Consultation Response from KC, Conservation & Design
2022/91524 24, Zetland Street, Huddersfield, HD1 2RA
Change of use and alterations to residential dwelling to form mixed use comprising drinking establishment with expanded food provision, leisure facility and retail sale of specialist tobacco (Listed Building within a Conservation Area)
Date Responded: 28.3.2023
Responding Officer: Sue Brooks
Responding Ref: HUD 4/1411

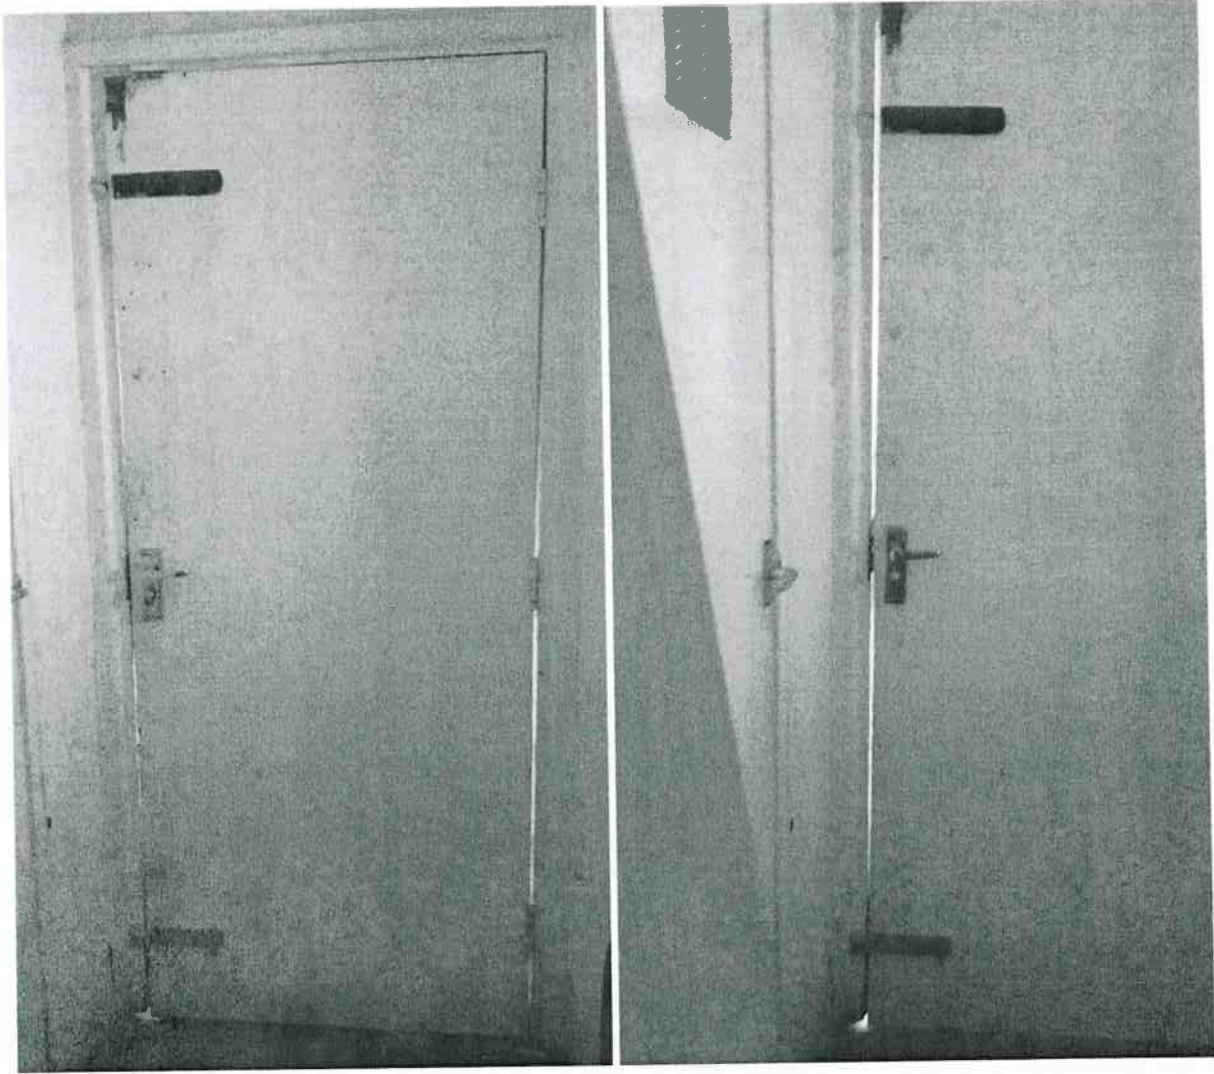
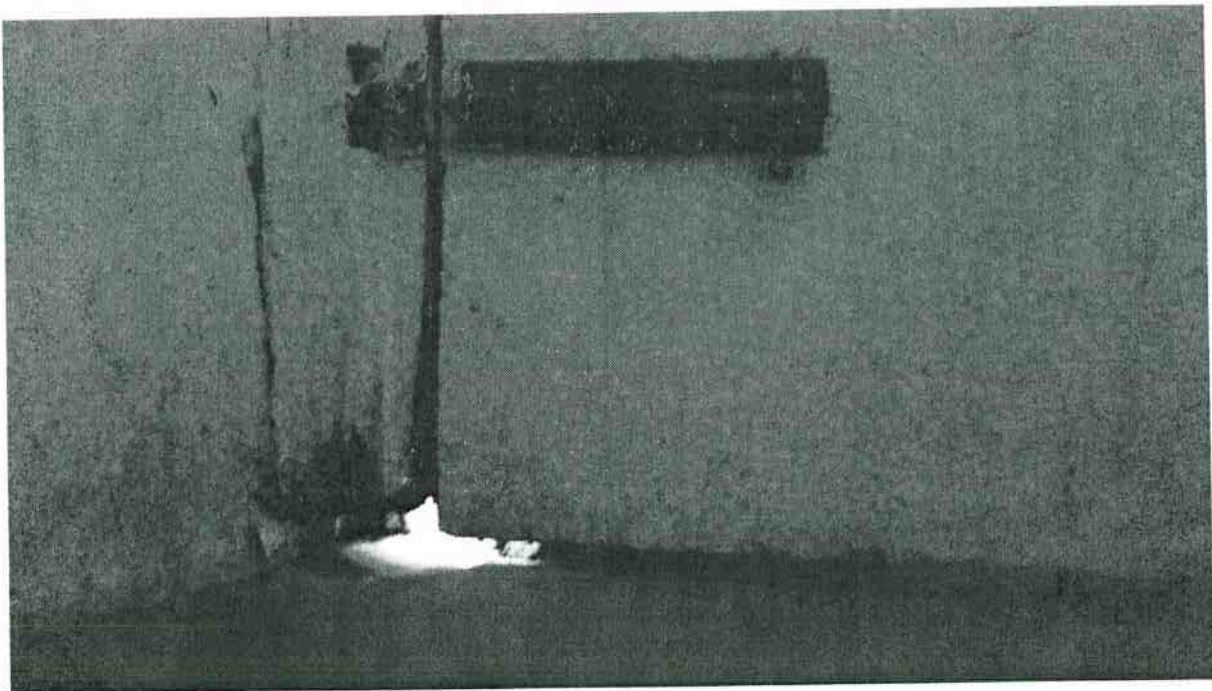
Fire doors are proposed on the ground and first floor. No details of the proposed doors have been submitted. The application form states that the timber panelled front door will be retained, while Appendix 8 states that it will be replaced - this door must be retained and repaired. The rear external door is not historic, and a replacement door may be acceptable subject to details being submitted.

Design spec for pergola

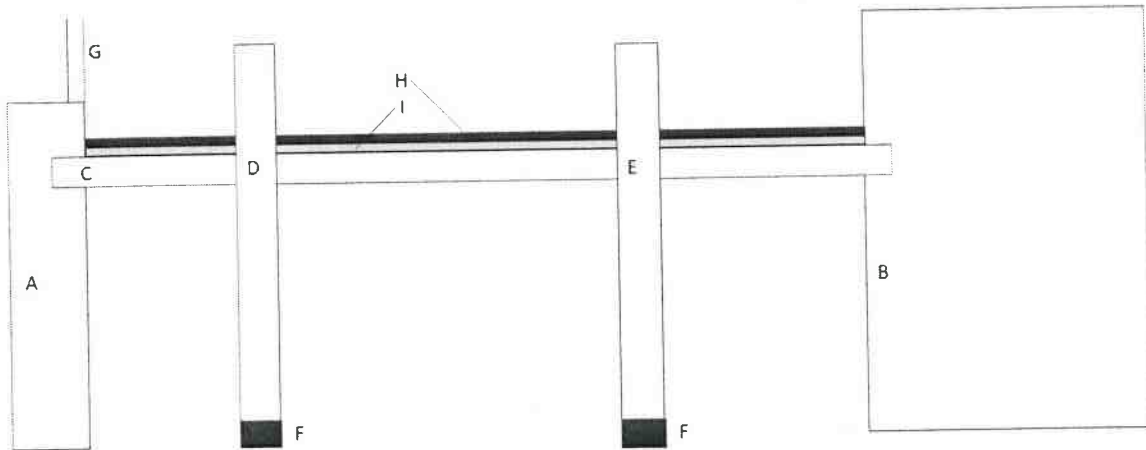
A substantial pergola is proposed in the rear yard, with the beams bedded into the rear wall of the listed building by a minimum depth of 150mm (Appendix 4, page 2). The pergola is shown on the proposed roof plans and north elevation A drawings. The submitted detail is limited and no justification has been provided for an intrusive construction method which causes damage to the building.
